Five Estuaries – Deadline 6 Submission

On behalf of my clients, T. Fairley & Sons Ltd, I am writing to provide an update on work undertaken by my client and the Applicant in relation to screening proposals. This has partly been recorded within the technical note: **10.20.8 Technical Note - SCREENING PLANTING OPTIONS FOR LAND PLOT 17-024. Document Number: 10.20.8 REP4-038.**

The alternative potential option for landscape screening of Normans Farm within plot 17-024, titled “Normans Farm Layout 3”, which was discussed at a meeting on the 22nd November 2024, is the preferred Layout of the three proposals, however, subject to the following outstanding amendments/concerns:-

DRAWING TITLE:
NORMANS FARM LAYOUT 3

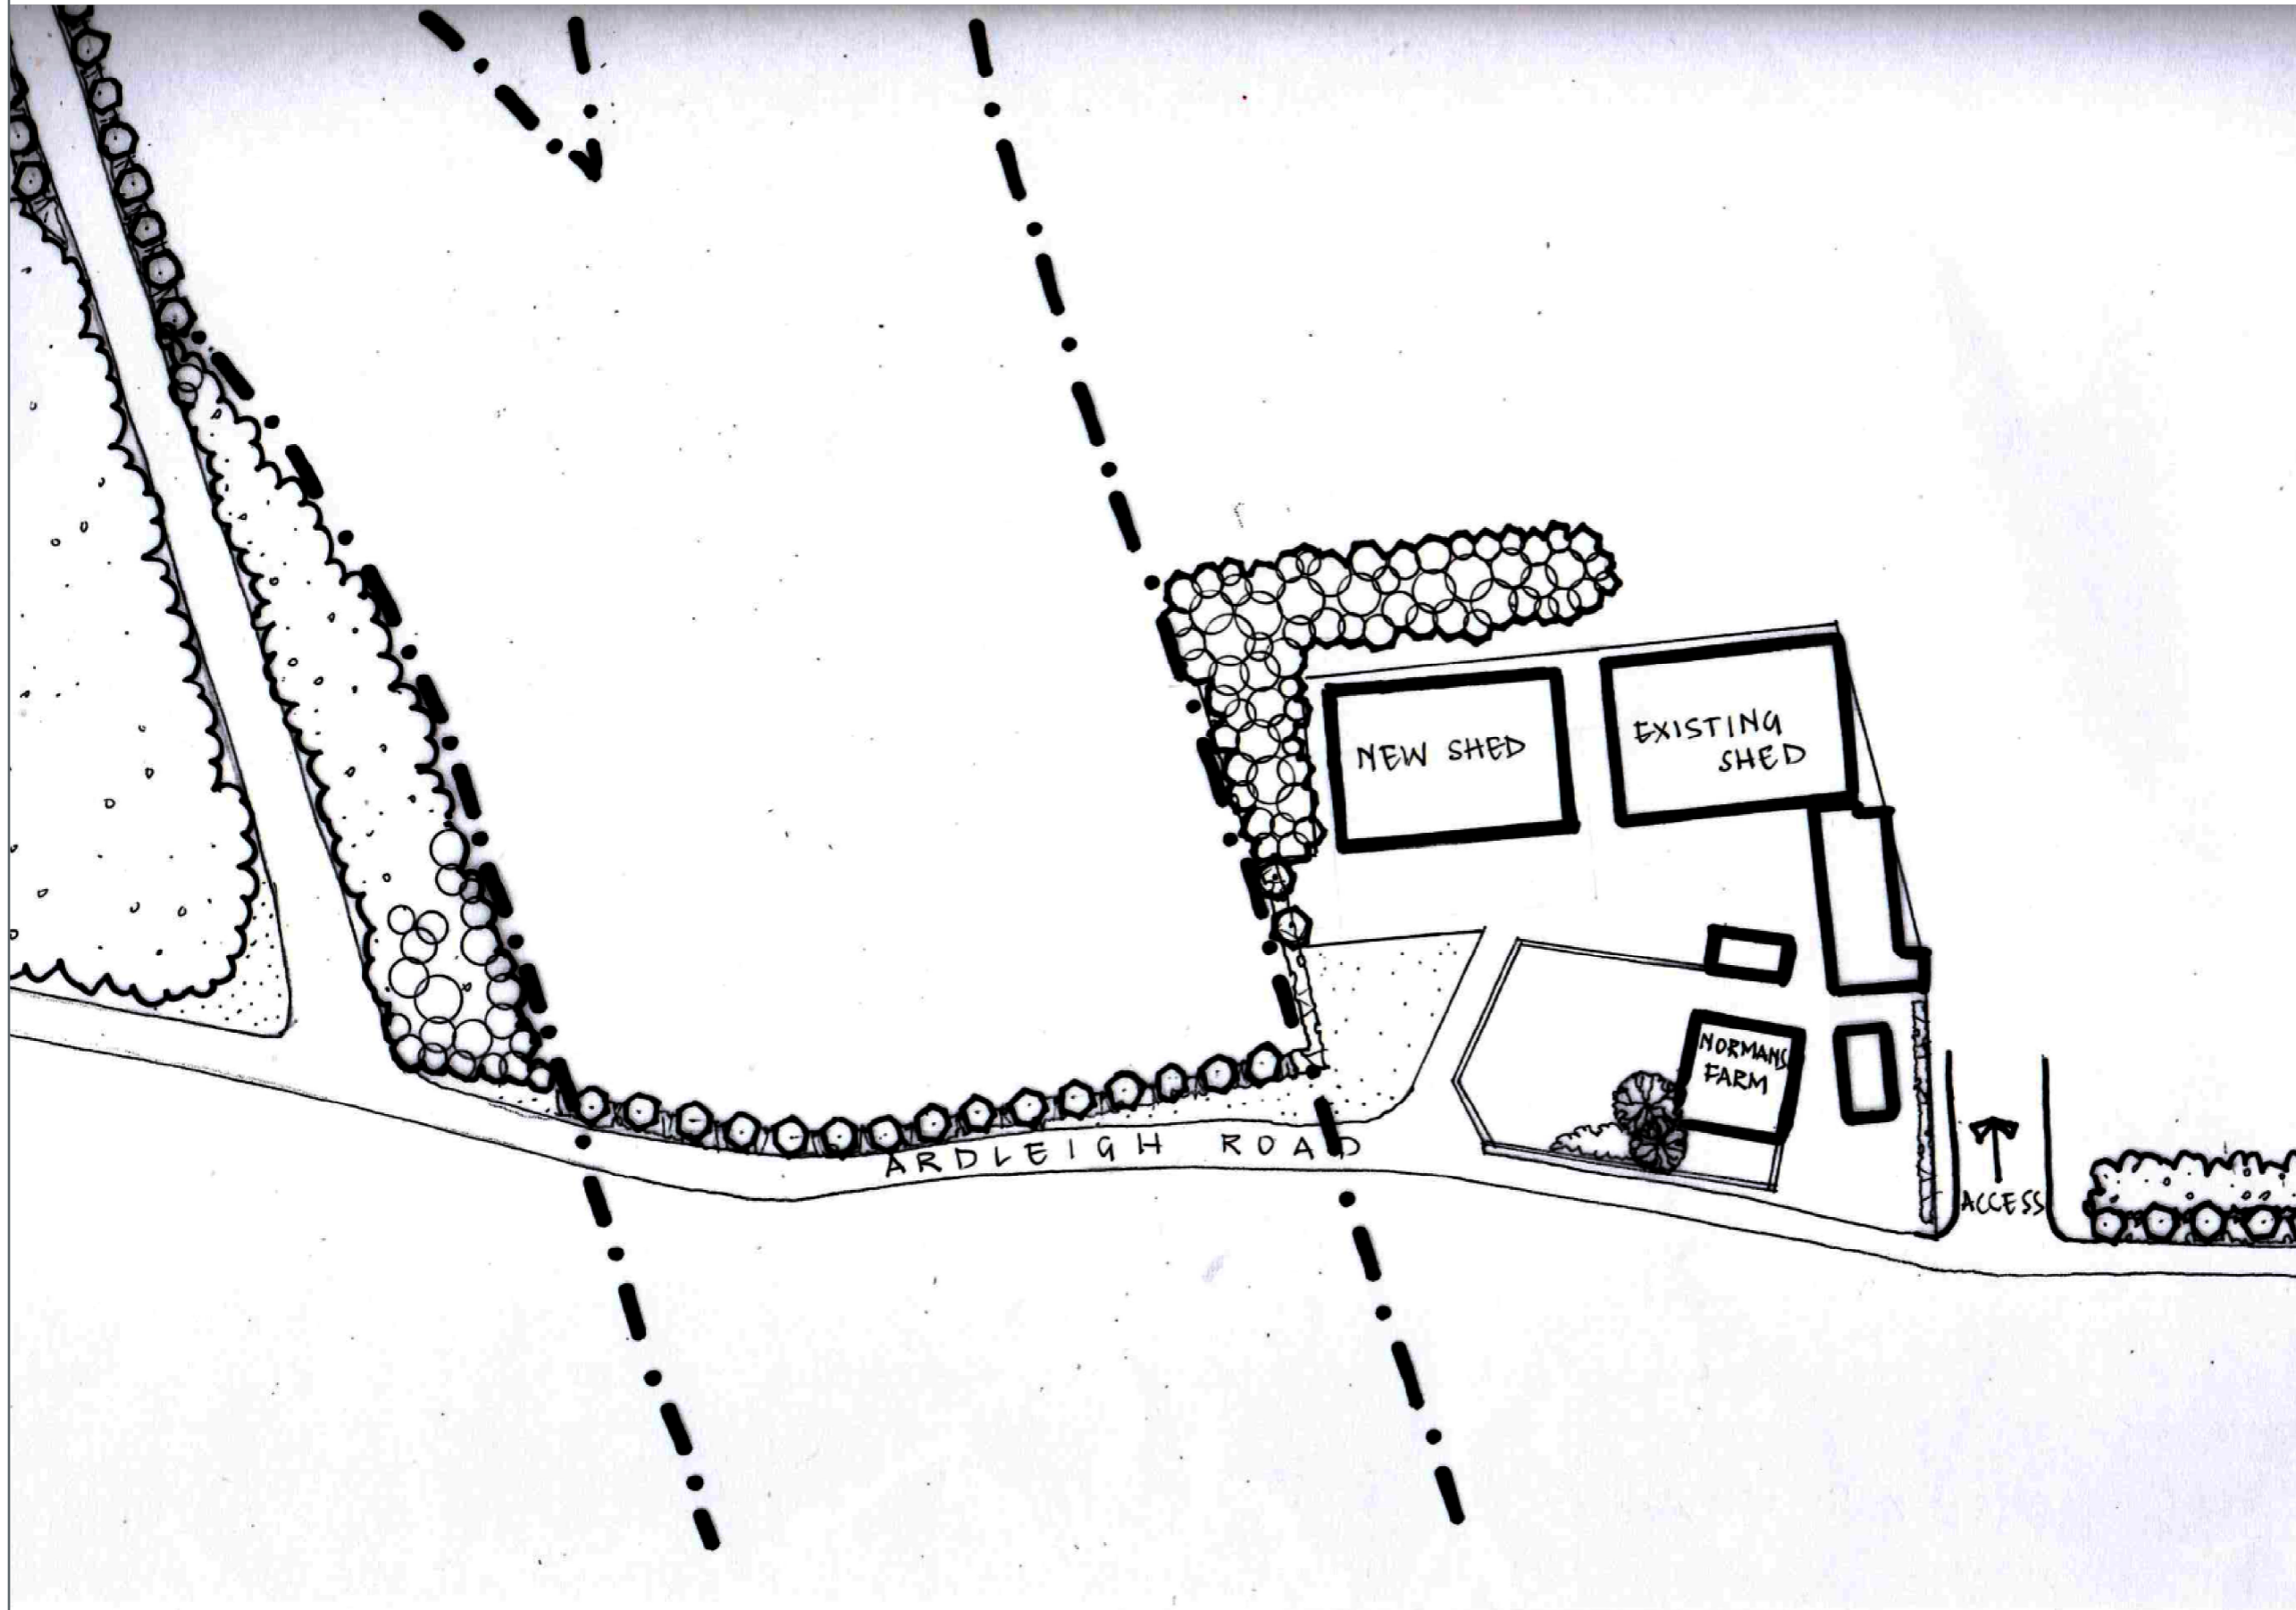
- b. The screening proposal to the north and west of the New Shed only allows for a circa 5,000 sq. Ft building, which is insufficient for the demands and requirements of my clients farming business.

- c. The screening proposal does not allow for access into the western gable end of the ‘New Shed,’ and with the proximity of the of the New Shed to the Existing Shed, access would not be available into the eastern gable end either, rendering the New Shed useless/land locked. This emphasises how Layout 3, despite having moved the screening belt away from the yard, still prohibits all future yard extension and construction of new buildings. We cannot stress this enough, that my client cannot be in a position where they are unable to extend their yard or construct new farm buildings. This will totally restrict future business growth, which is not a position the Applicant should be putting my client in.

- d. It was understood that the New Shed would remove the need of a screening belt around the yard, thus preventing any future sterilisation. It was also discussed during the meeting on 22nd November 2024, that by Five Estuaries (and North Falls), constructing a new building on our clients behalf, it would remove the need for both projects to acquire the land at the proposed rate, removing the costs in establishing the screening belt and removing an element of management liability for the screening belt, thus being a possible cost equal exercise. This proposal would clearly benefit all parties, and especially my client as no screening belt would prevent any restrictions on future expansion of the yard and buildings. To reemphasise our concerns, our client cannot and must not be in a position where the future growth of their business is prevented due to the presence of the screening belt.

- f. As to the proposals of Establishing a screening belt along the northern edge of Ardleigh Road, this will have a detrimental impact to the arable land immediately to the north as during the winter months, the soil will not dry out as it will always be in this shadow of the screening belt. We appreciate and understand the need for a screening belt along this stretch of road, protecting the vista from users of Ardleigh Road, however, we request with the screening belt could be kept as sporadic and low as possible, to protect the productivity of the soil immediately to the north.

- g. As to the access to the east of Normans Farm and as shown in Normas Farm Layout 3, we had agreed with the Applicant agreed sufficient width would be removed from the screening belt to allow future access for large agricultural machinery and which my client would retain ownership of. The Normans Farm Layout 3 proposals show such access. We support such access to the land to the east of Normans Farm, and the proposals as per the Applicants drawing suggests the access is circa 27 meters wide. This allows for future agricultural uses and provides a 'corridor' for future services being laid (for uses such as irrigations mains, electricity supplies, etc). In any case, we cannot have an access any narrower than 20 metres. We also agree with the positioning of the access, as the existing buildings will provide a natural visual screen from the substation site for Ardleigh Road users, thus providing the opportunity to not establish a screening belt for the last circa 27 metres, as drawn.

- h. As to the position of the cable corridor, and whilst we appreciate the corridor delineates a 'worst case scenario', perhaps it would be best for Five Estuaries (and North Falls) to use all best endeavours to microsite the cables to the western side of the proposed corridor, thus providing the opportunity to further extend the yard to the west in due course.
